**Addendum No. 2**

RE: Contract # C204833  
WBS # 47988.3.1  
FEDERAL AID NO. 4798831  
**New Hanover and Pender Counties (I-6039)**  
I-40 FROM MM-420 TO MM-408 AT NC 210.

**July 18, 2023 Letting**

The following revisions have been made to the Roadway Plans.

TYPICAL SECTION NO. 1

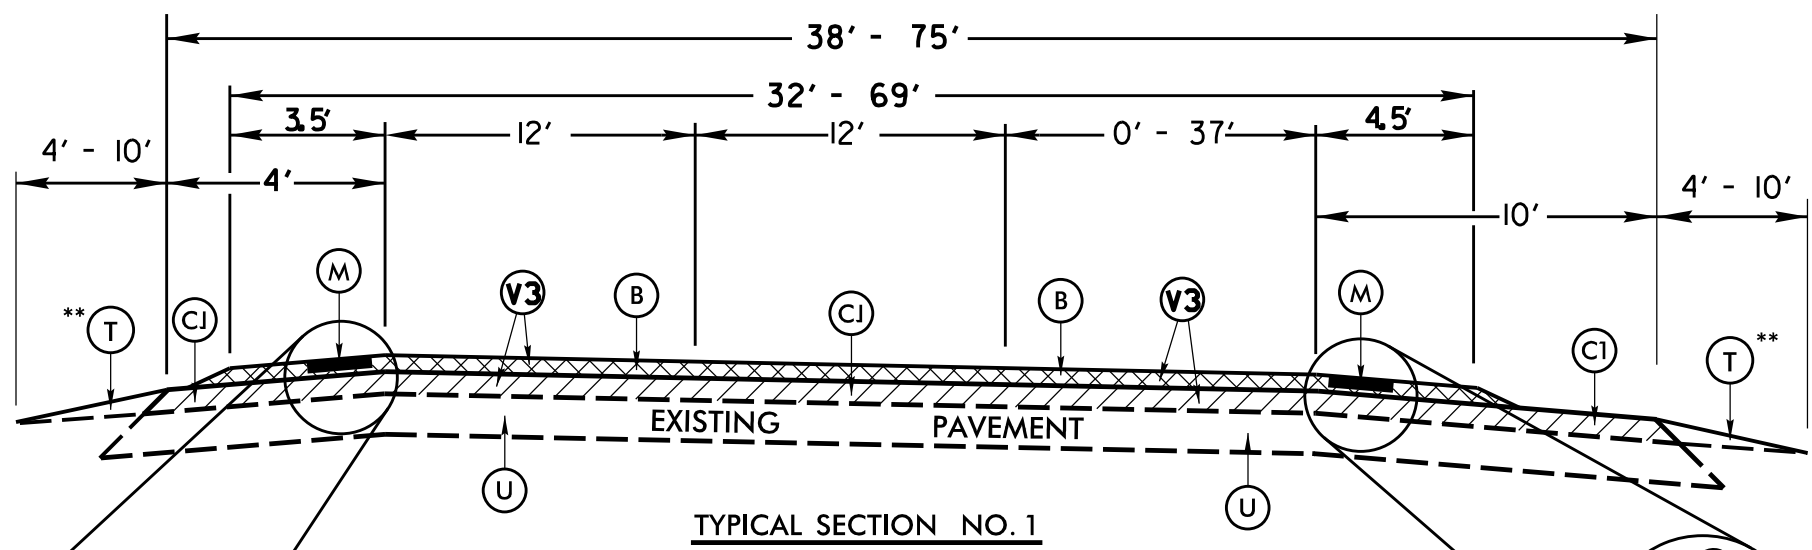
Sheet No.	Revision
3	V3 callouts on Typical No. 2 revised. V3 Milling Note added above Pavement Schedule.
6	V3 Milling Note added below Pavement Schedule.
